KITTITAS COUNTY

MEMORANDUM

TO: Jeff Watson, Community Development Services
FROM: Christina Wollman, Planner II *CW*
DATE: July 6, 2011
SUBJECT: Olexsy BL-11-00011

**OLEXY PROPERTY**

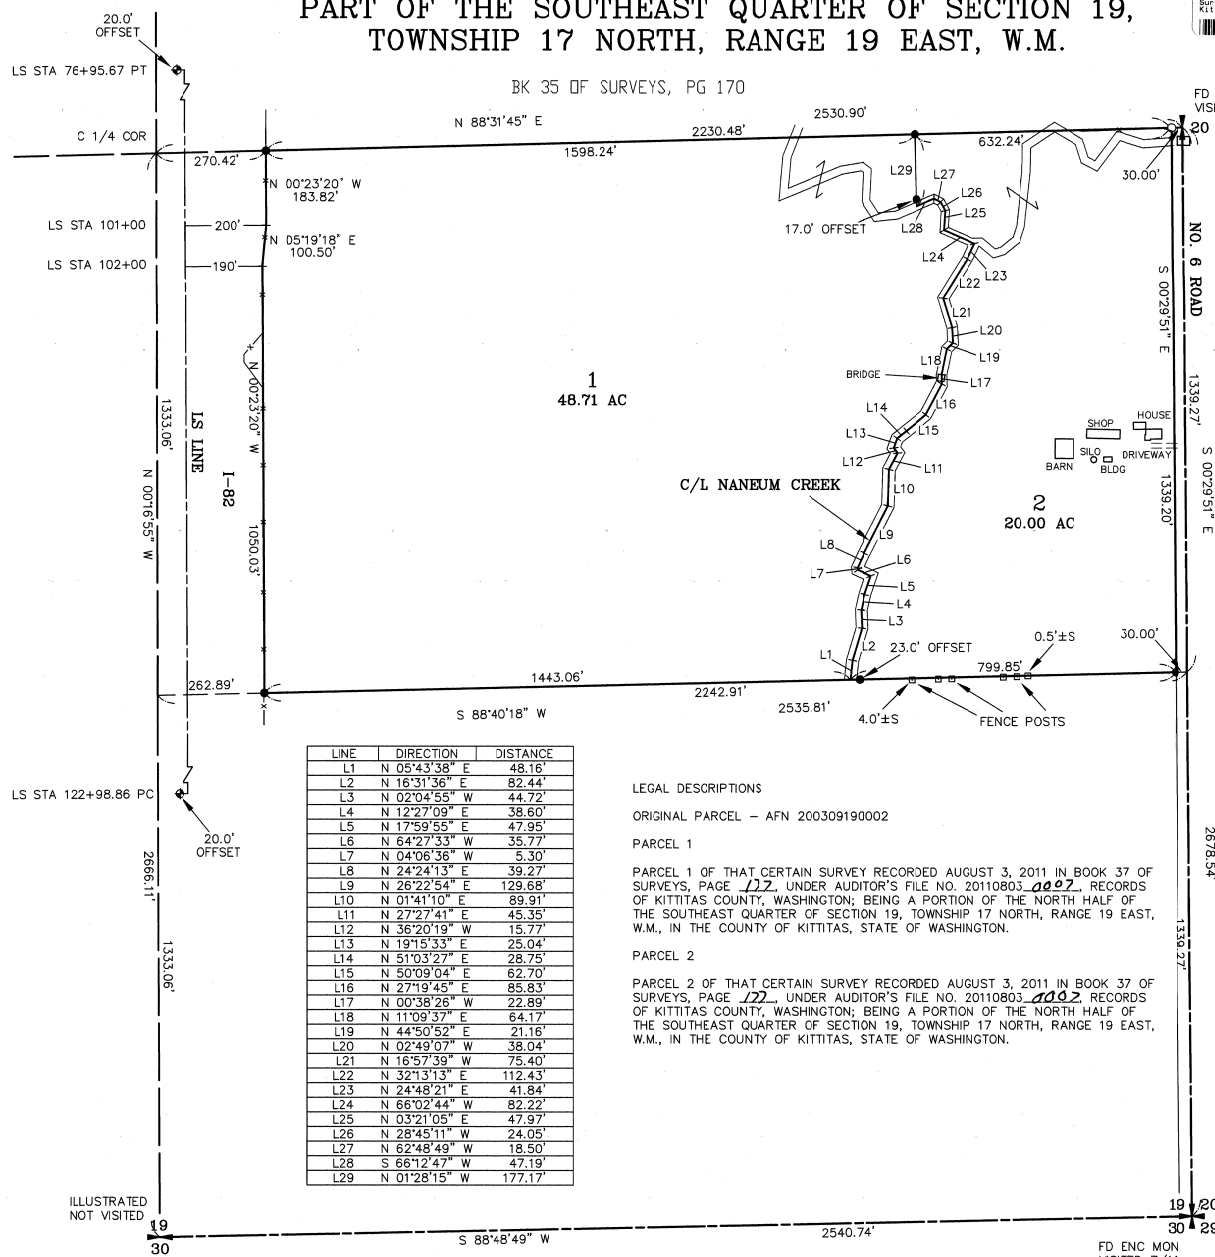
1. A revised legal description that describes the final configuration of the subject property shall be required.
